Date: 30 January 2019  
Your reference: MP10\_0046 MOD 4  
Our reference: DOC19/66112  
Contact: Calvin Houlison  
4224 4179

**RE: Russell Vale Colliery Modification 4 (MP 10\_0046 MOD 4) Response To Submissions**

Attachment A: OEH Detailed Comments on Russell Vale Colliery Modification 4 (MP 10\_0046 MOD 4)

APPENDIX F
PROPOSED SCENARIO FLOOD MAP

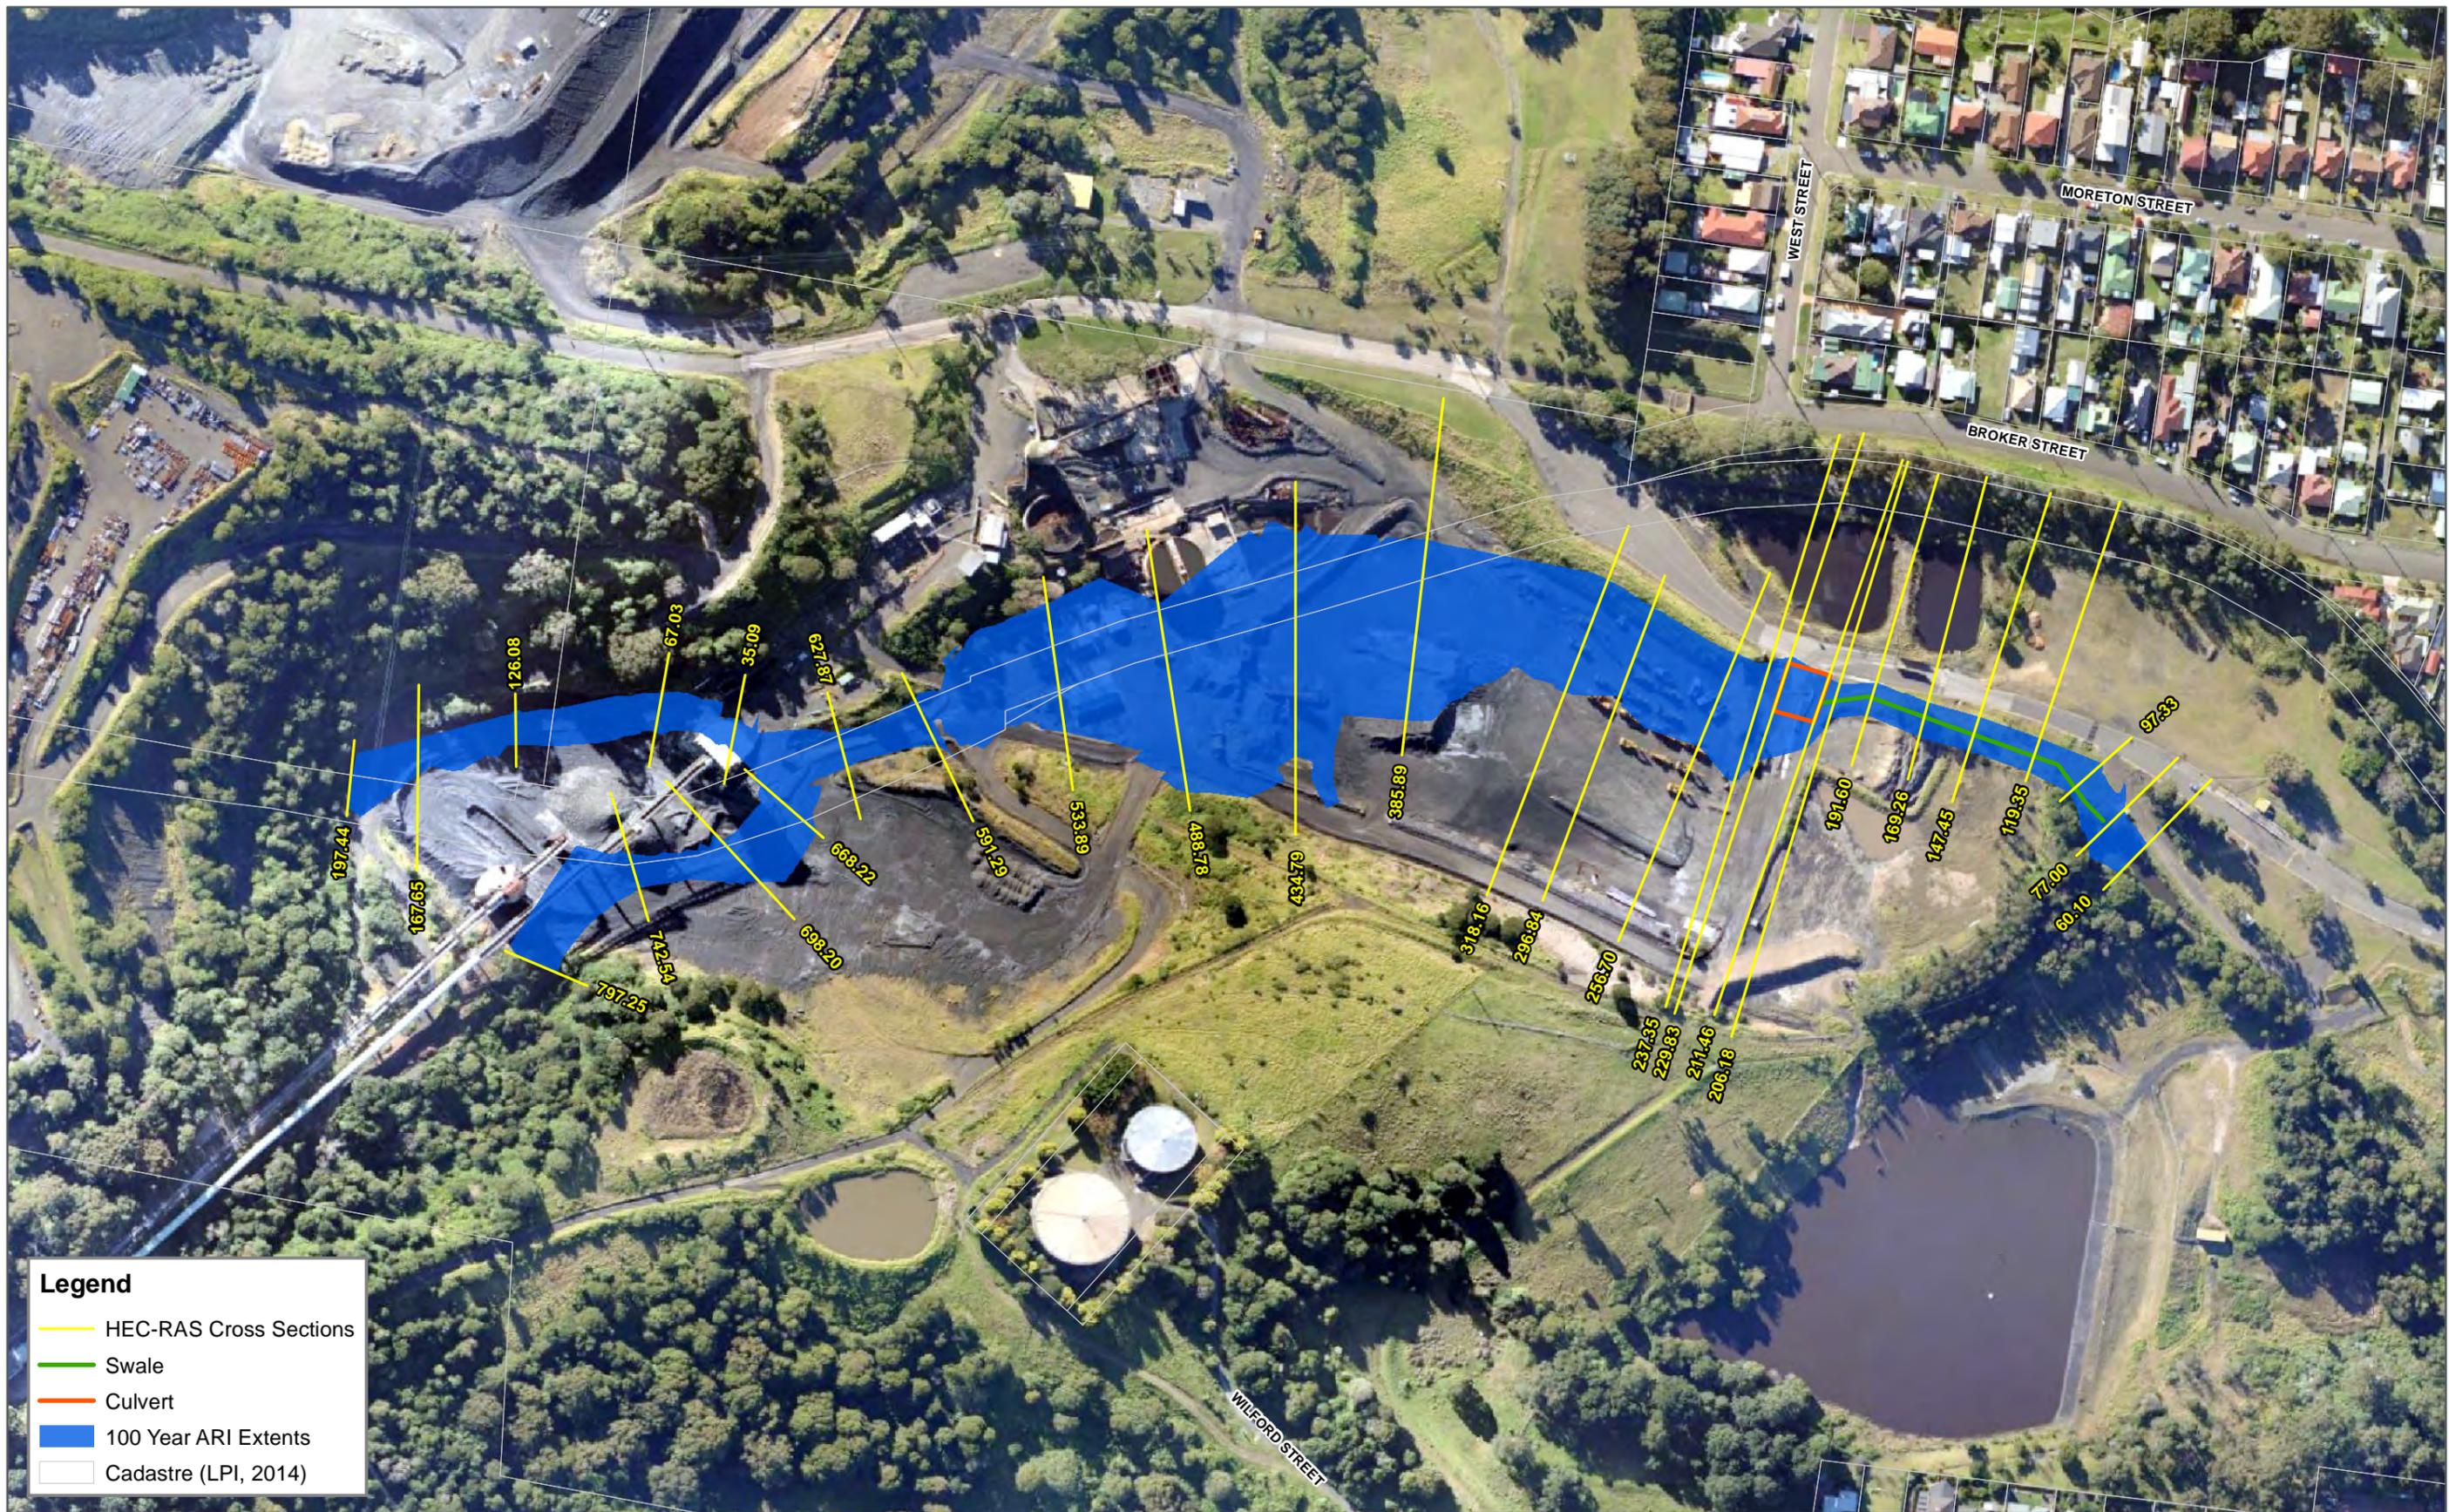
- The report contends that the Cardno (2015) approach is unsuitable due to increases in peak flows at the Princes Highway. This is contrary to results provided which included a refined sediment basin (as per Cardno (2015) recommendation) to prevent bypass of dirty water flows. The flood impact map of the Cardno (2015) approach with refined basin shows flood level reductions at downstream locations.

APPENDIX G
PROPOSED MITIGATION STRUCTURES

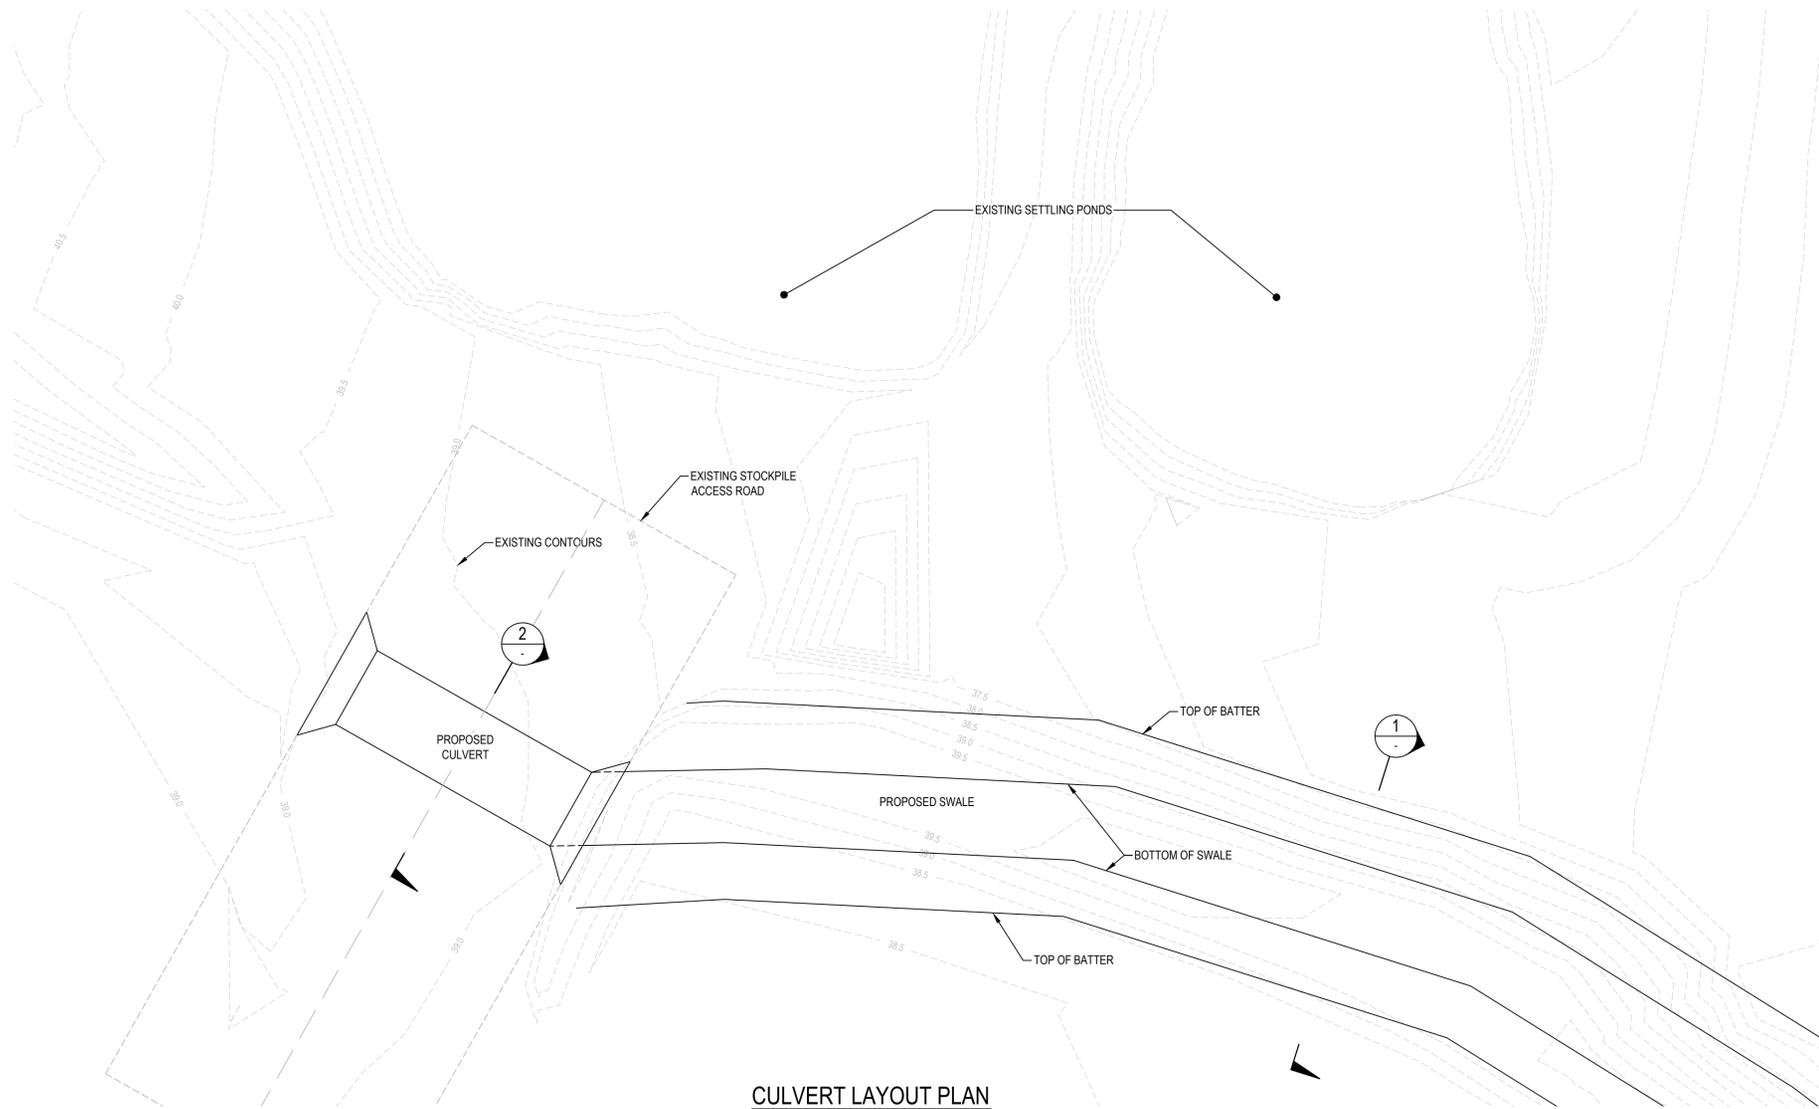
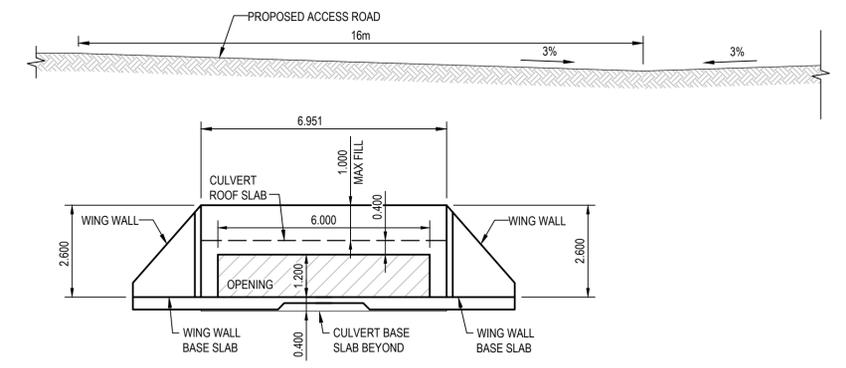
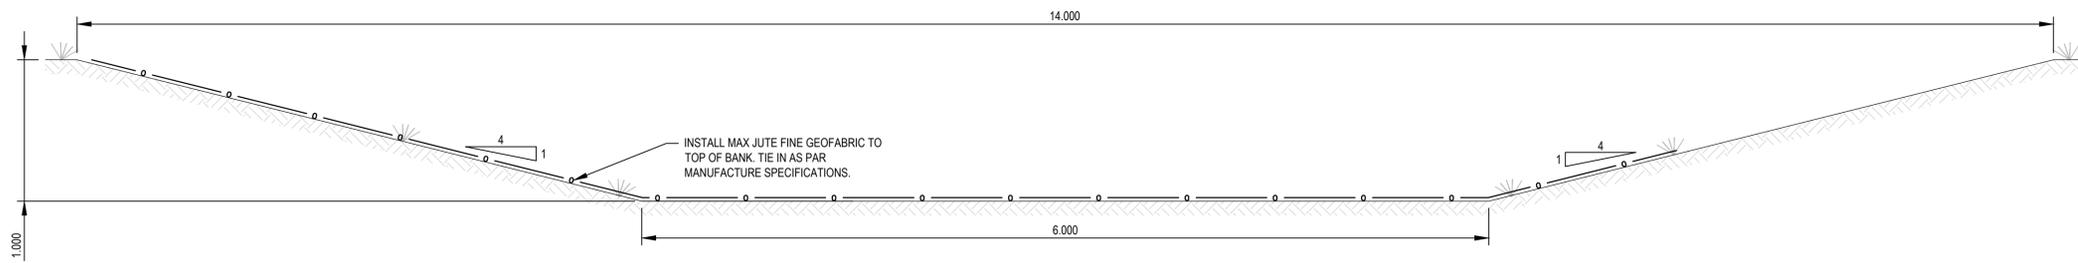
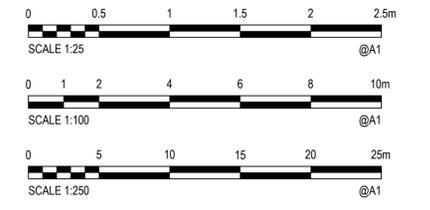
- The assessment concludes that the culvert, swale and access road upgrades proposed by Cardno (2015) are not required. However, it is understood these measures were put in place to off-set the impact of uncontrolled and untreated flows from the site. It is therefore unclear whether incorporation of these elements (or a refinement of them considering revised modelling, survey and blockage assumptions) into the proposed approach would be more effective in minimising or preventing overflows from the site.
